U.S. Department
of Transportation
**Federal Aviation
Administration**

October 9, 2018

RE: Meadowlake Ranch Development, EA # EA17227 - File # SKP184

SKETCH PLAN

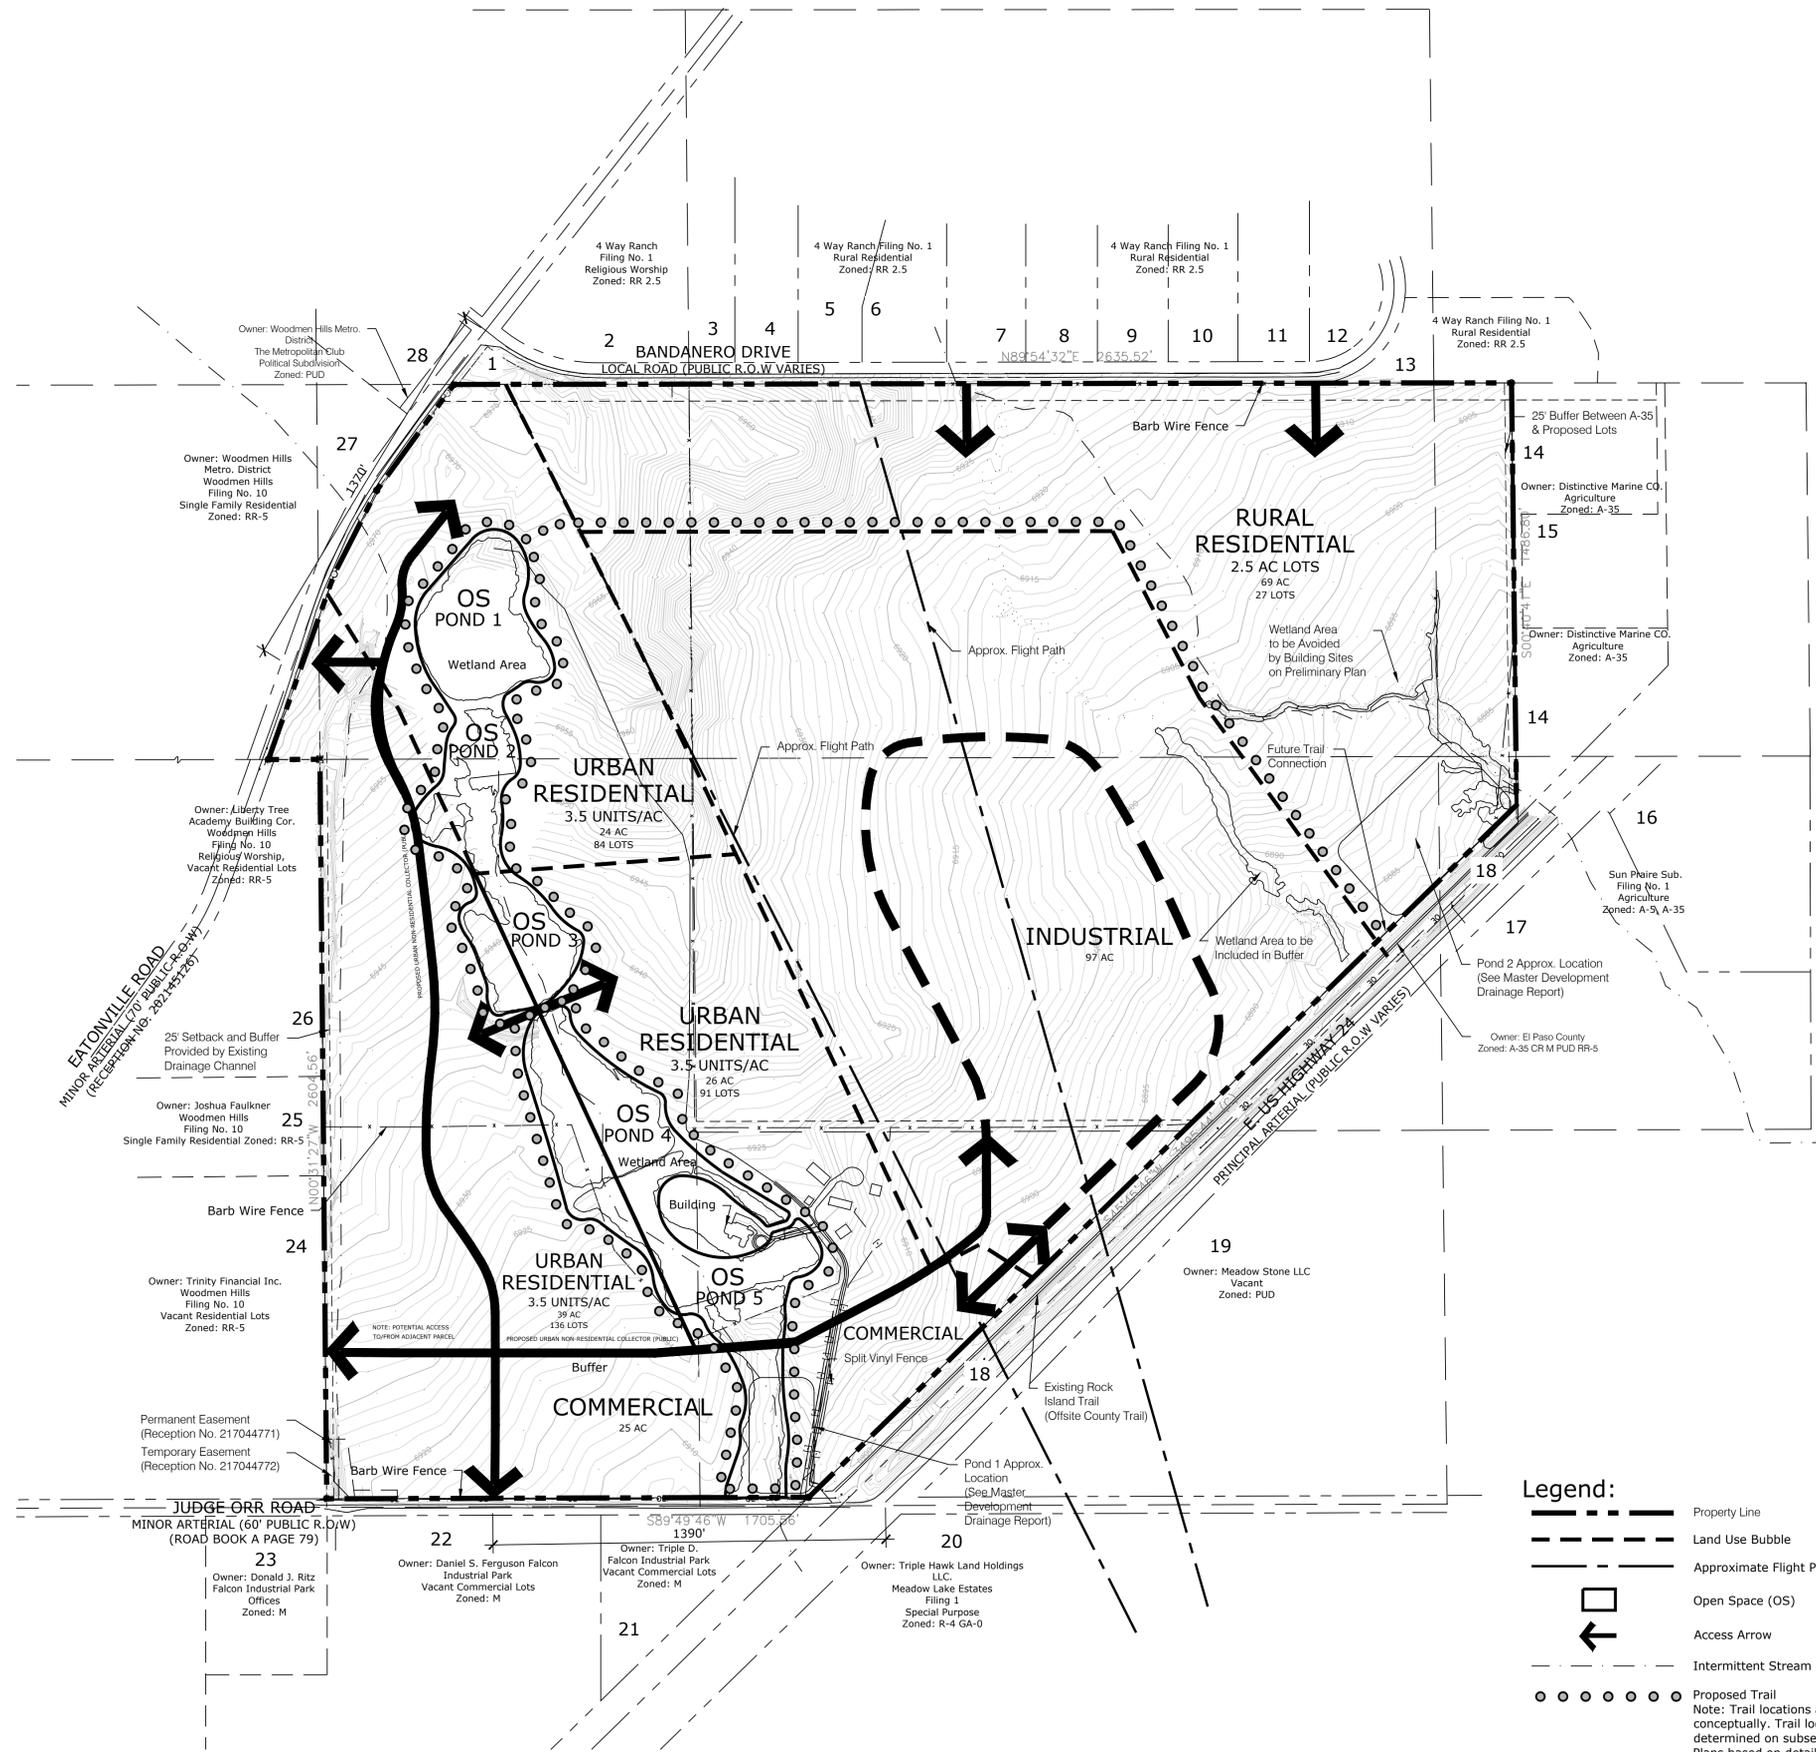
The southern boundaries of the proposed Meadowlake Ranch is less than 1,300 feet from the end of Runway 15/33 along the extended centerline of this runway. Runway 15/33 is the primary runway at Meadow Lake Airport, serving approx. 95 percent of the airport's annual aircraft operations. This means residents of Meadowlake Ranch will be subject to an average of 95 overflights daily. These aircraft will be at low altitudes as they approach and depart the airport. In accordance with standard operating procedures, aircraft approaching and departing Runway 15/33 could be operating at altitudes lower than 400 feet above the proposed project. This is particularly the case over higher terrain to the north of the airport.

Although the frequency of aircraft accidents is comparatively very low, the numbers of aircraft using the concentrated airspace of airport approach and departure areas, together with the complexities of takeoff and landing operations, does mean that accidents are proportionately higher in those areas than in other locations farther away from airports. MLAA reports that aircraft annually make emergency landings in the area of the proposed development. Most of these aircraft can be towed back to the airport because they have landed in an open field. The most recent incident was on August 23, 2018, when an aircraft lost power and crashed in the area of the proposed development, approx. a ¼ mile north of Runway 15/33. This aircraft sustained substantial damage. This is why the FAA strongly discourages the congregation of people under airport traffic patterns and approach and departure areas. The proposed Meadowlake Ranch development is within the approach and departure areas for Runway 15/33.

For the reasons discussed above, the FAA cannot support the construction of residences so close to Meadow Lake Airport. We recommend El Paso County not approve residential development as proposed and explore alternative uses of this land that better conform with Federal, state and industry recommendations for compatible land uses near airports.
